Town and Country Planning Act 1990 (as amended)
Section 73 Application – Variation of Conditions 2 (Approved Plans) and 13 (Replacement Wind Turbine)
Site: Grange Moor Coachworks, Barnsley Road, Grange Moor, Huddersfield, WF4 4DR
Application Ref: 2025/92971

This letter accompanies a minor amendment to the current application proposals. The amendment seeks to relocate the proposed wind turbine approximately 36 metres to the south of its previously submitted position.

Project Site Layout Plan	
Date 31/07/2026	
Scale 1:1250 @ A3

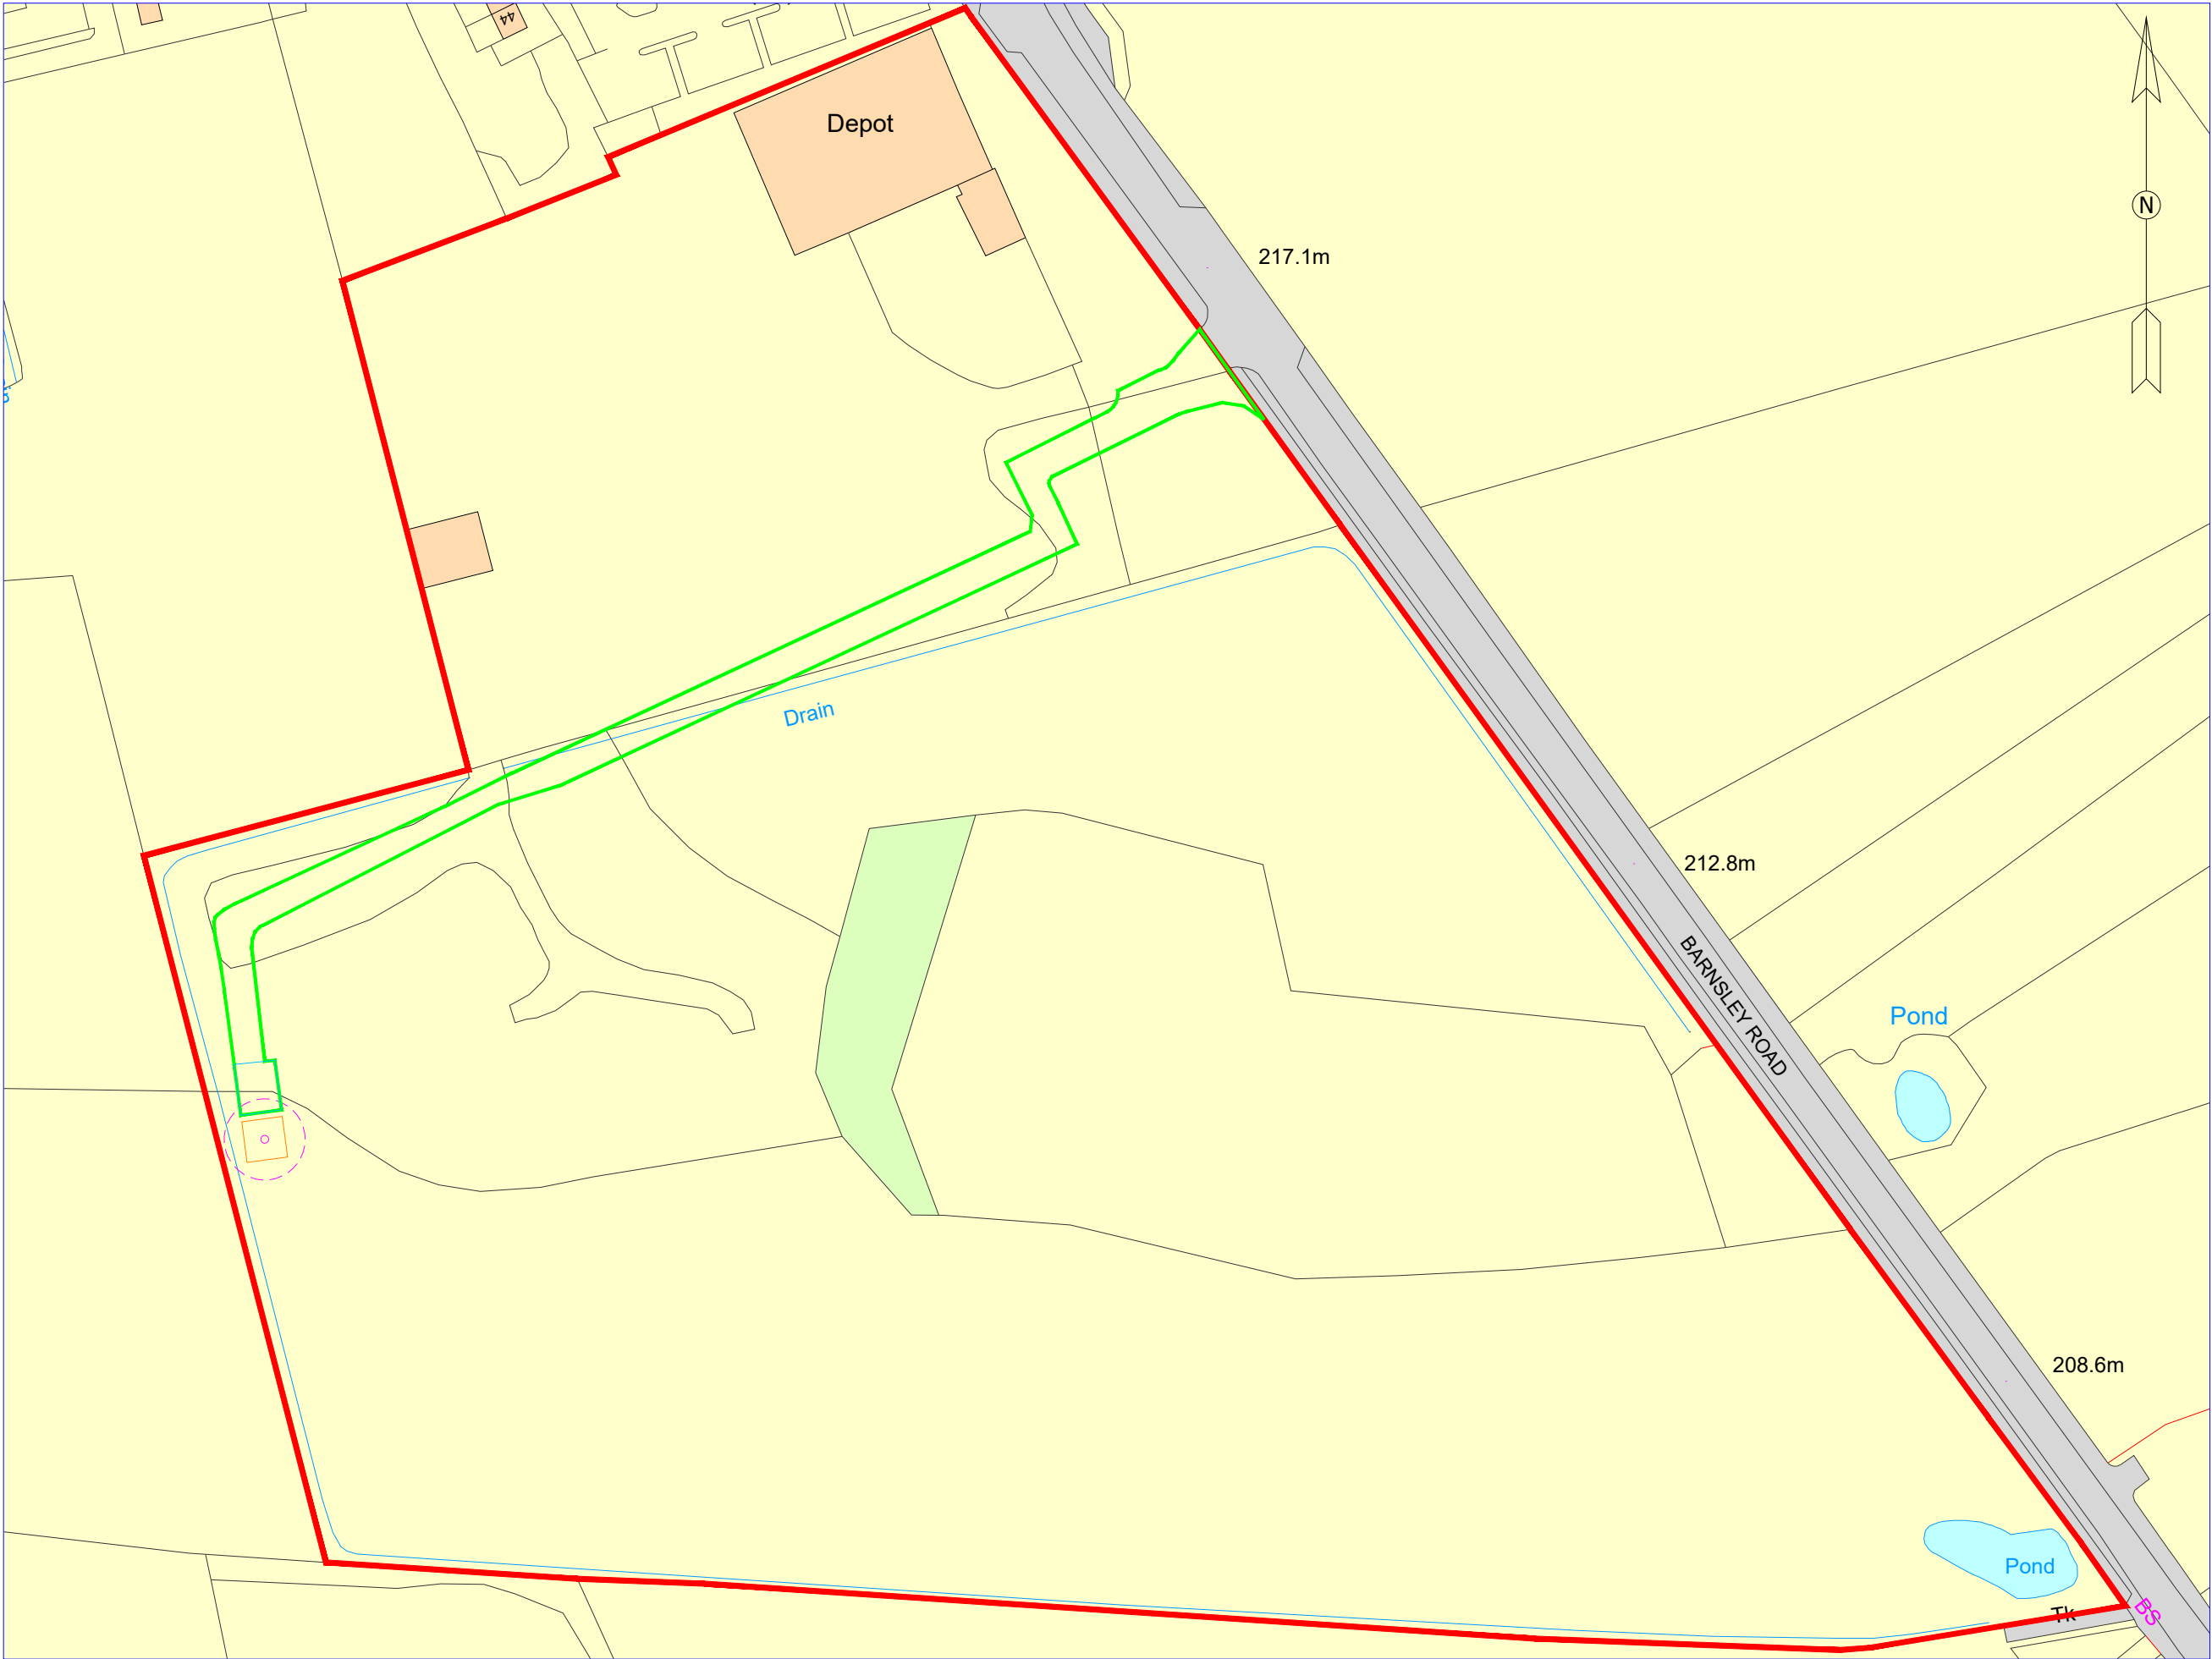
- Condition 2 (Approved Plans) – to reflect the revised site layout showing the relocated turbine; and
- Condition 13 (Replacement Wind Turbine) – to allow the turbine to be sited in the amended position rather than the previously approved location.

The relocation of the turbine further south will increase the separation distance from the nearest residential properties beyond the previously assessed “worst-case” scenario (approximately 178m) and will therefore provide an additional reduction in noise for these properties.
